Planning Act 2008 – Application by North Falls Offshore Wind Farm Limited for an Order Granting Development Consent for the North Falls Offshore Windfarm (EN010119)

I refer to the Rule 8 letter dated 4 February 2025 which sets out the Examination Timetable for the above Development Consent Order (DCO), currently at Examination. Essex County Council (ECC) in conjunction with Tendring District Council (TDC), and as described as The Councils, would like to provide a written response to the Applicant's submission at Deadline 4. Responses to ExQ2 are submitted separately.

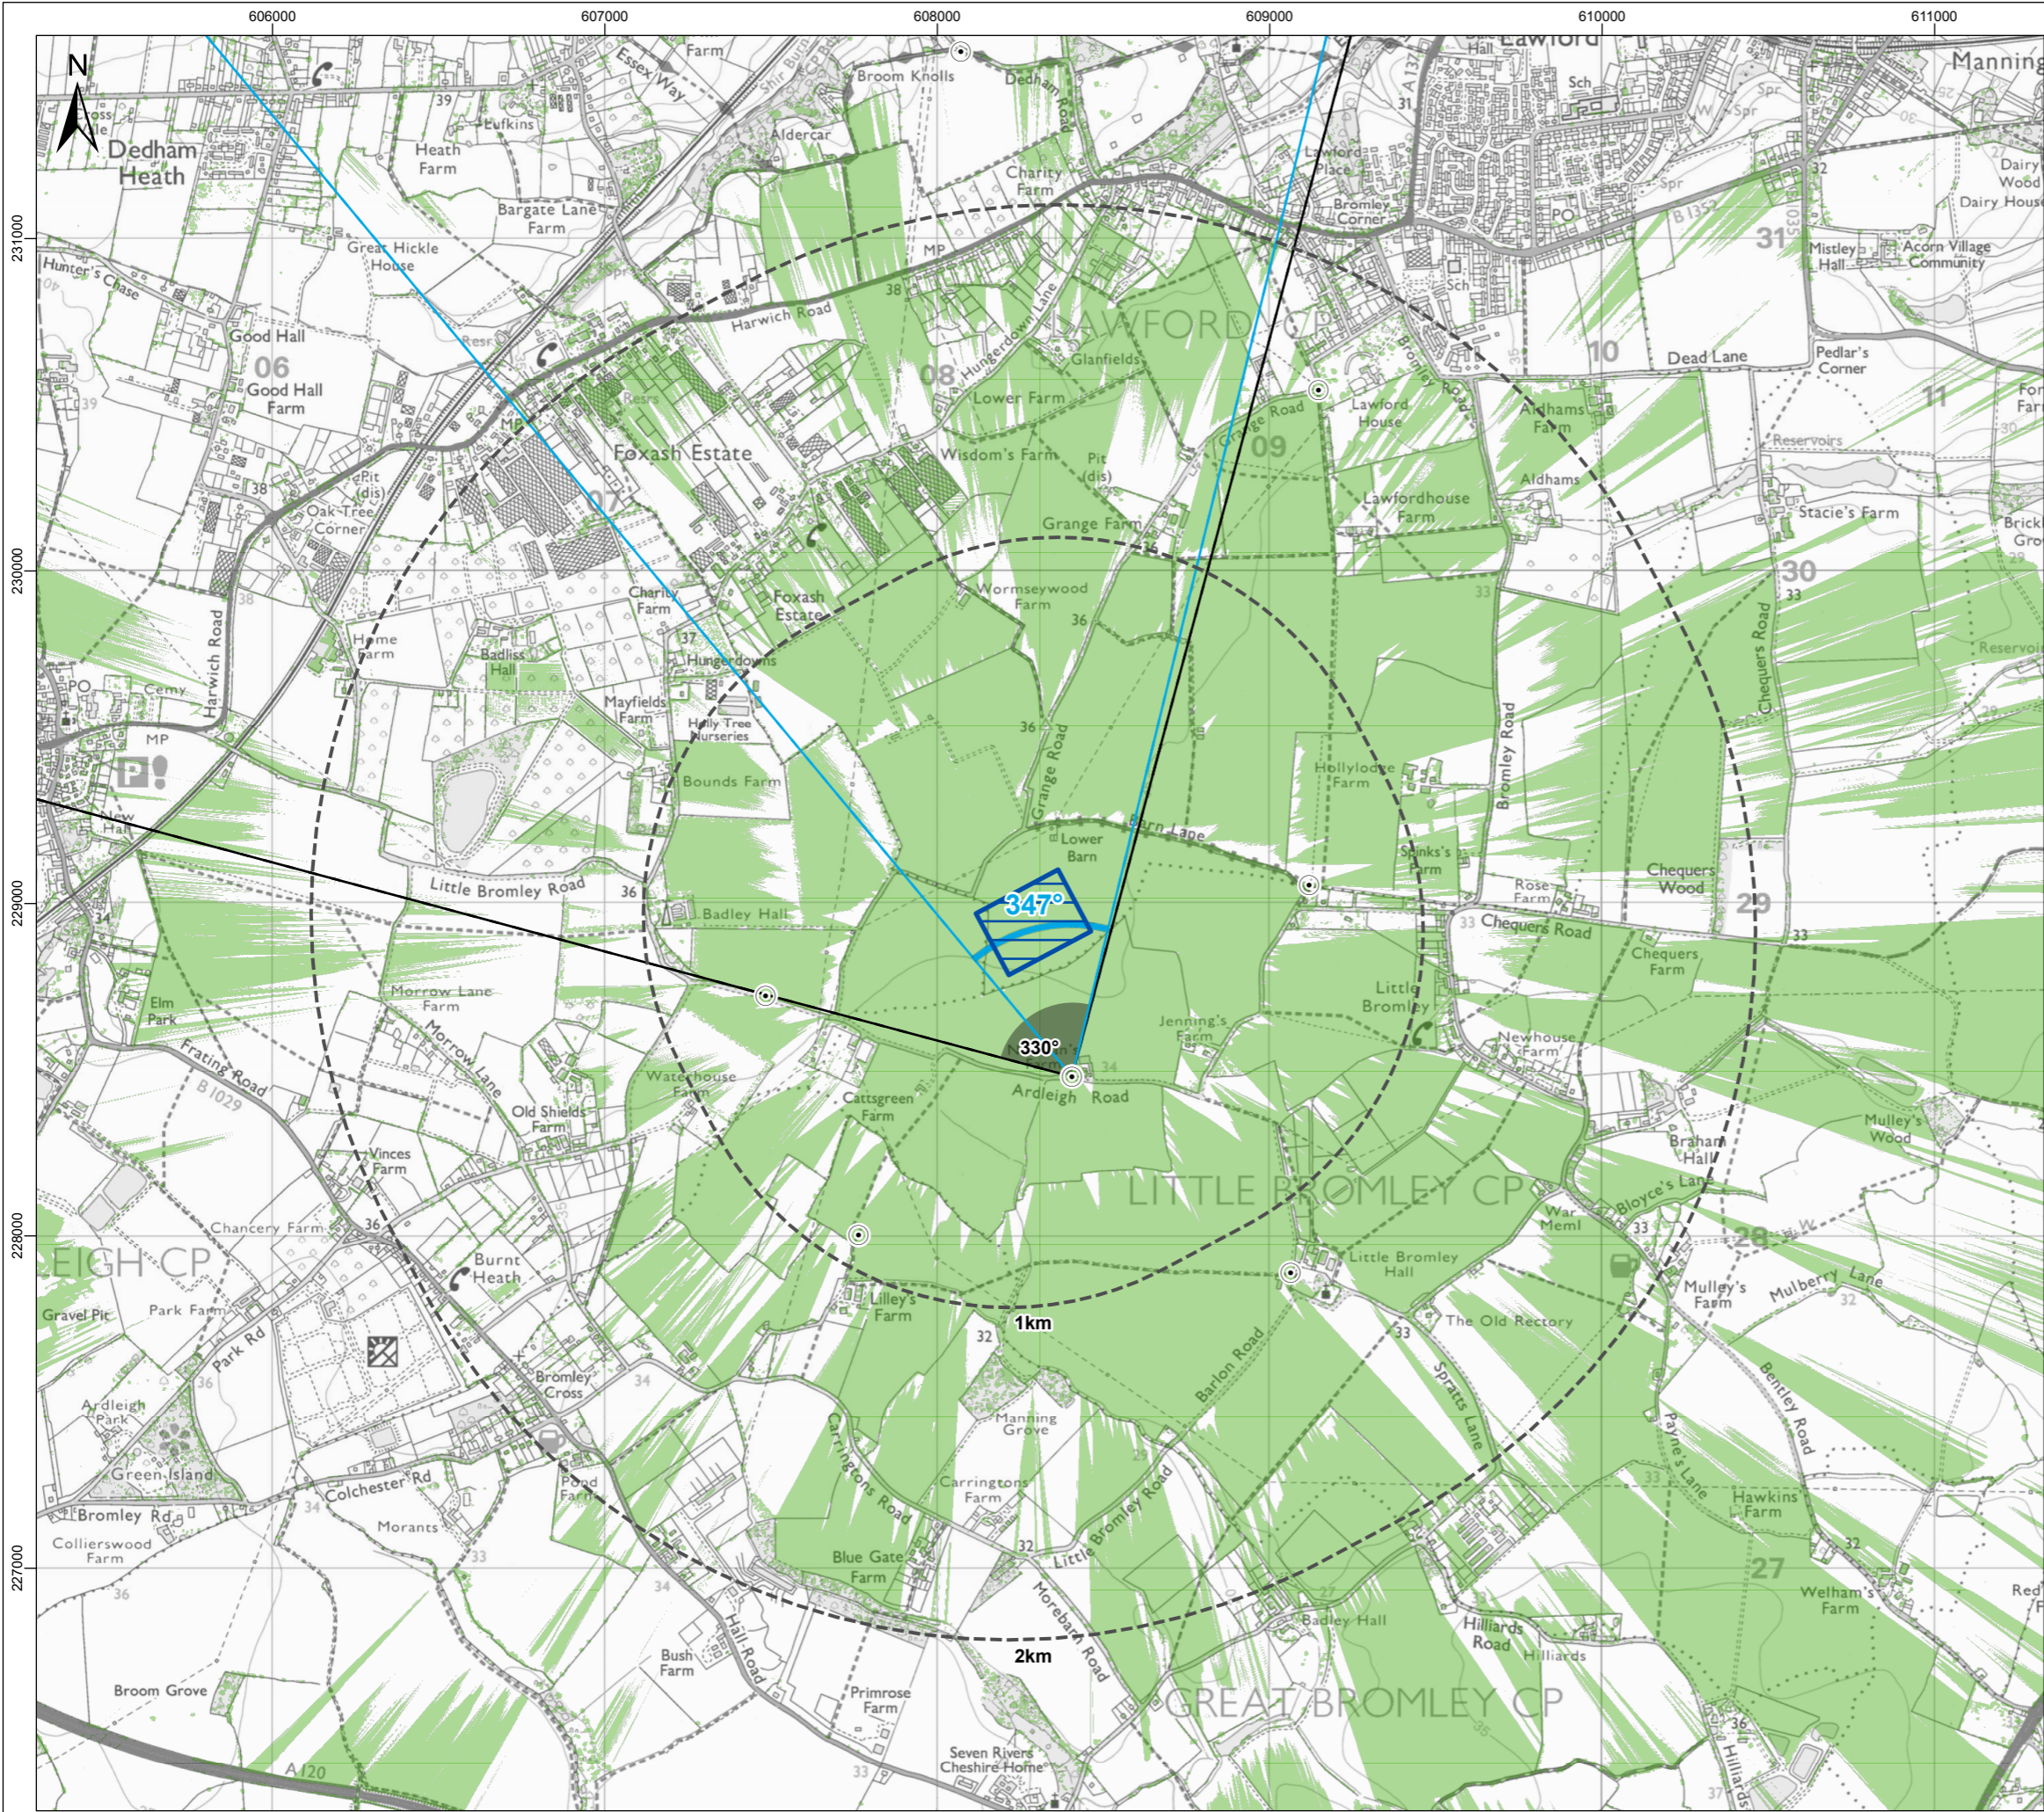
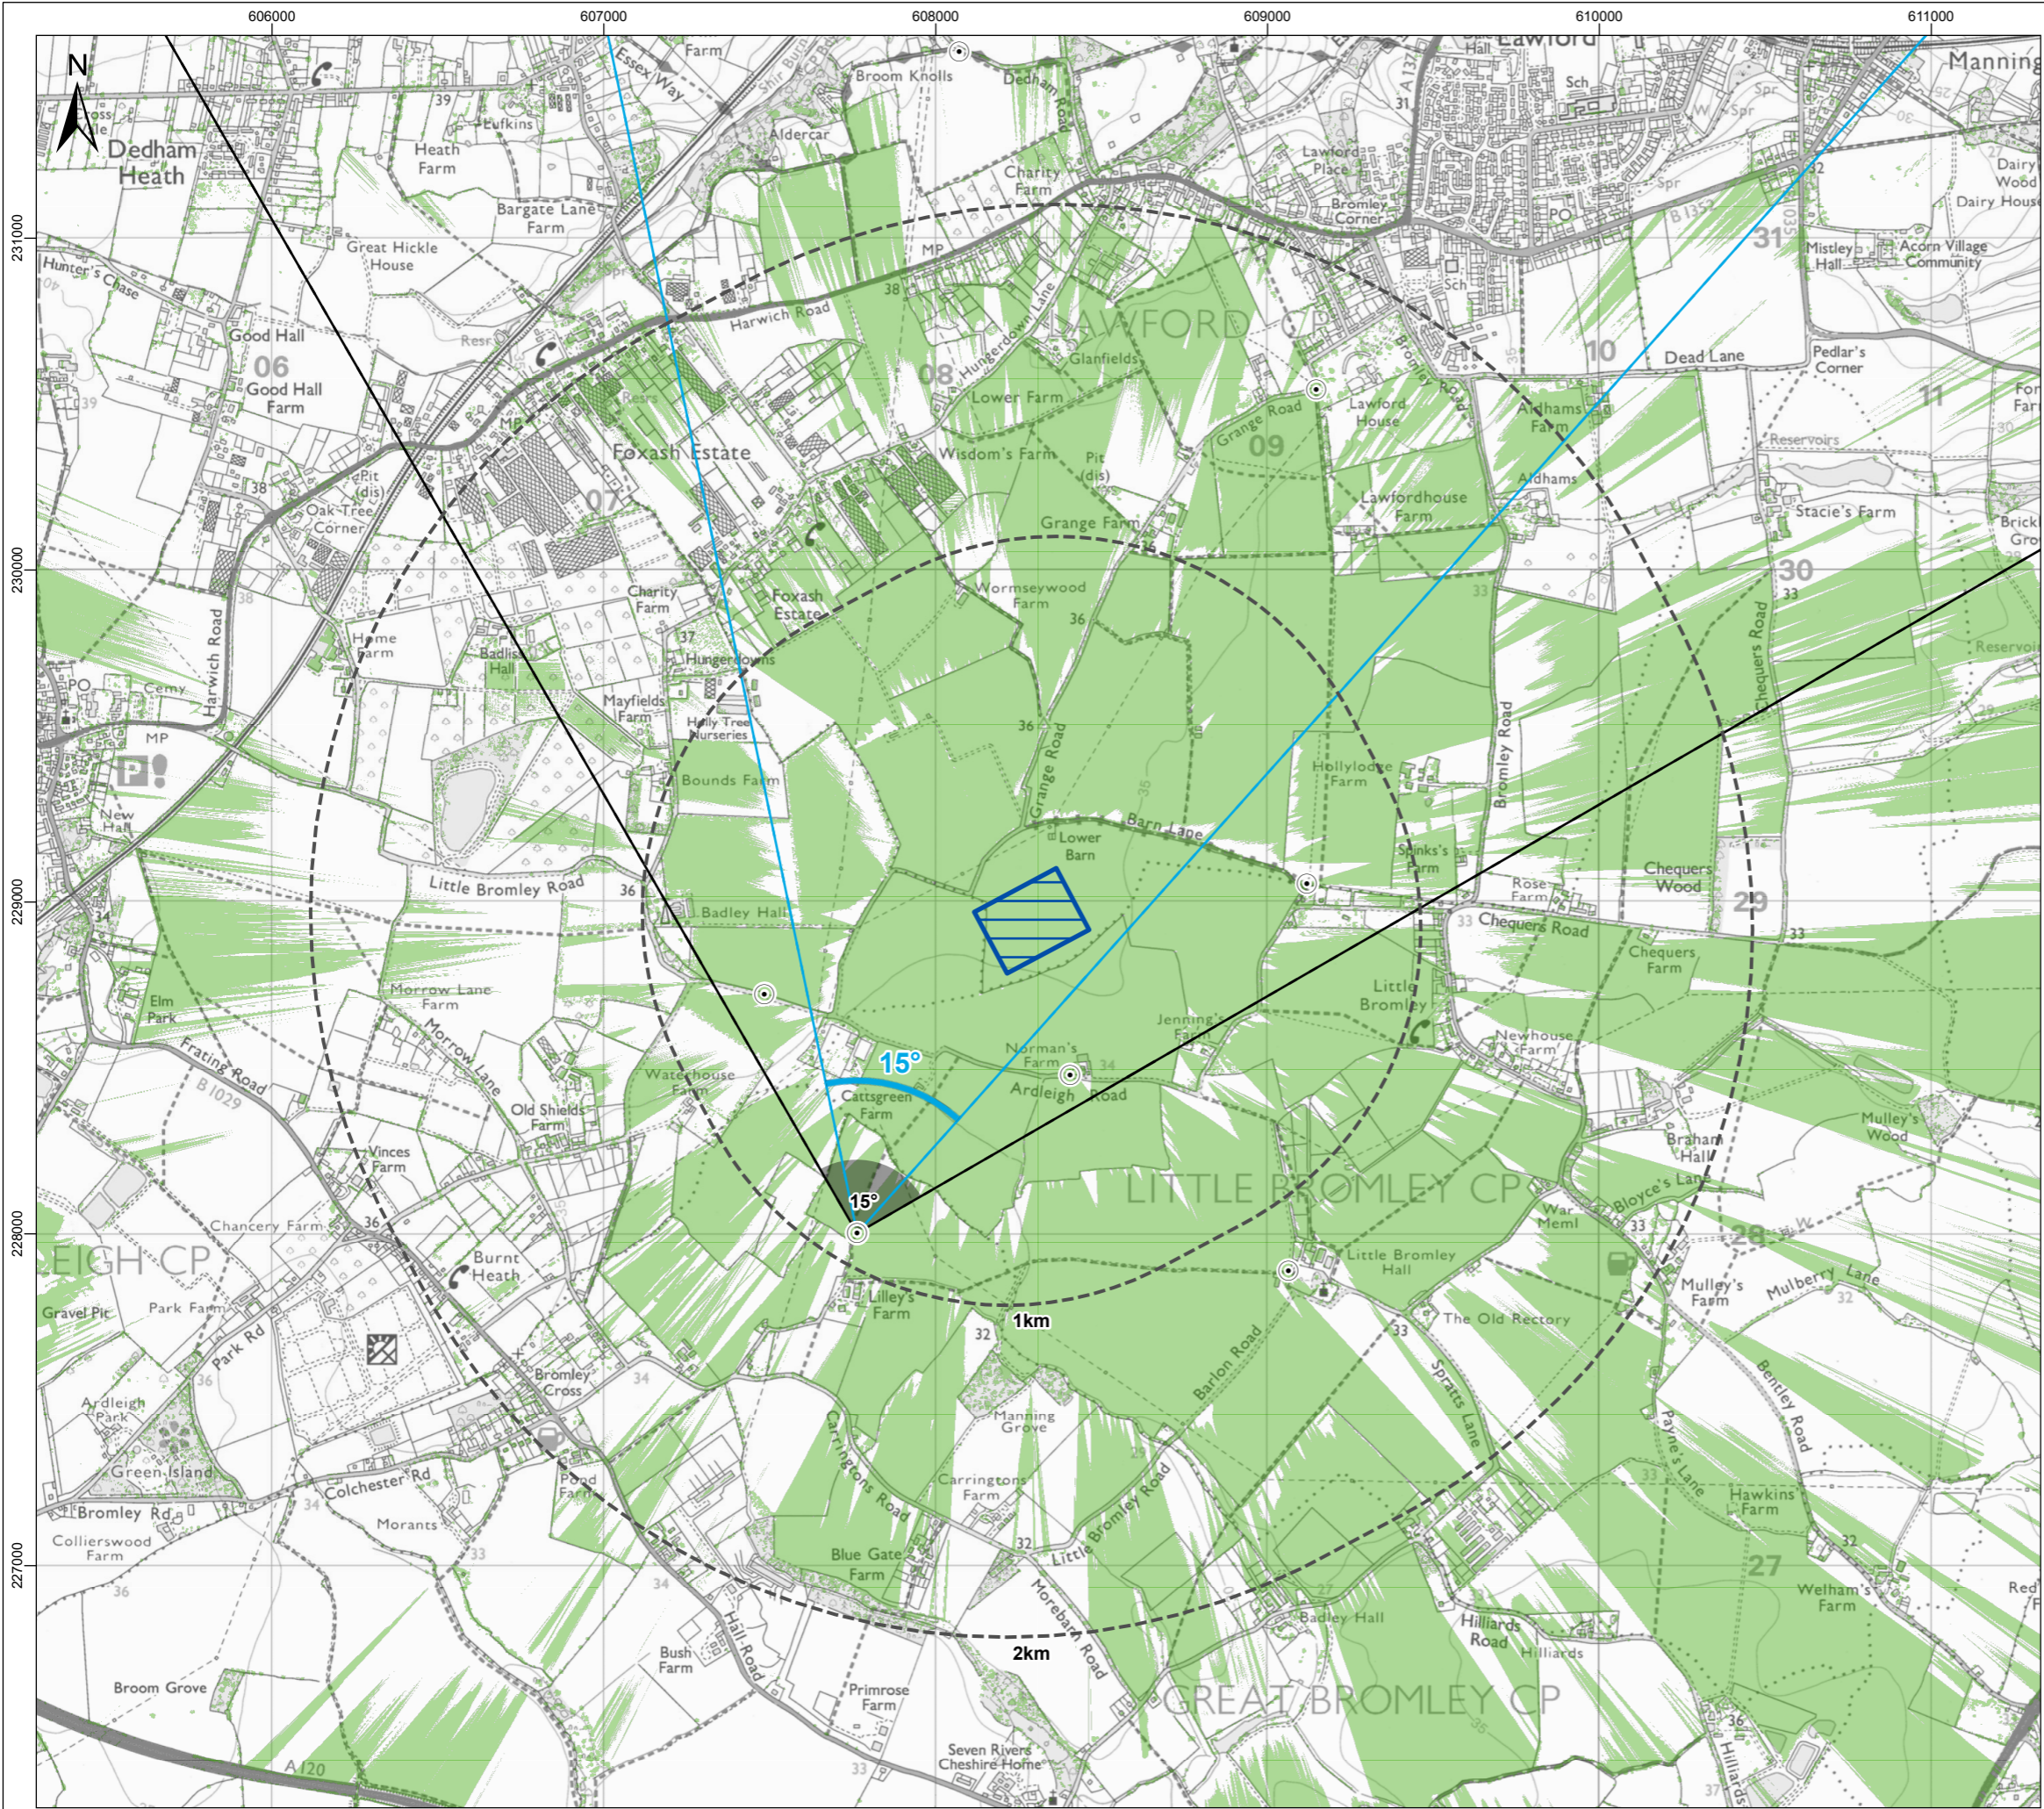
- Viewpoint (VP) 2 Bridleway Barn Lane c 600m distance
 - Demonstrates Year 1 would generate a likely Major negative i.e. significant impact.
 - The N2T pylons are substantially visible adding to the significant negative impacts.

- These impacts will likely magnify for receptors moving closer to the installations along the bridleway.
- VP 3 Norman's Farm c 350m distance
 - Demonstrates Year 1 would generate a likely Major negative i.e. significant impact

- The N2T pylons are substantially visible adding to the significant negative impacts.
 - These impacts will likely magnify for receptors moving closer to the installations along the Ardleigh Road

- VP 5 Public Rights of Way (PRoW) Lilley's Farm c 900m distance
 - Demonstrates Year 1 would generate a likely Mod/Major negative i.e. significant impact

- The N2T pylons are not visible but likely to become more visible as you move closer to the installations along the PRoW towards Ardleigh Road.
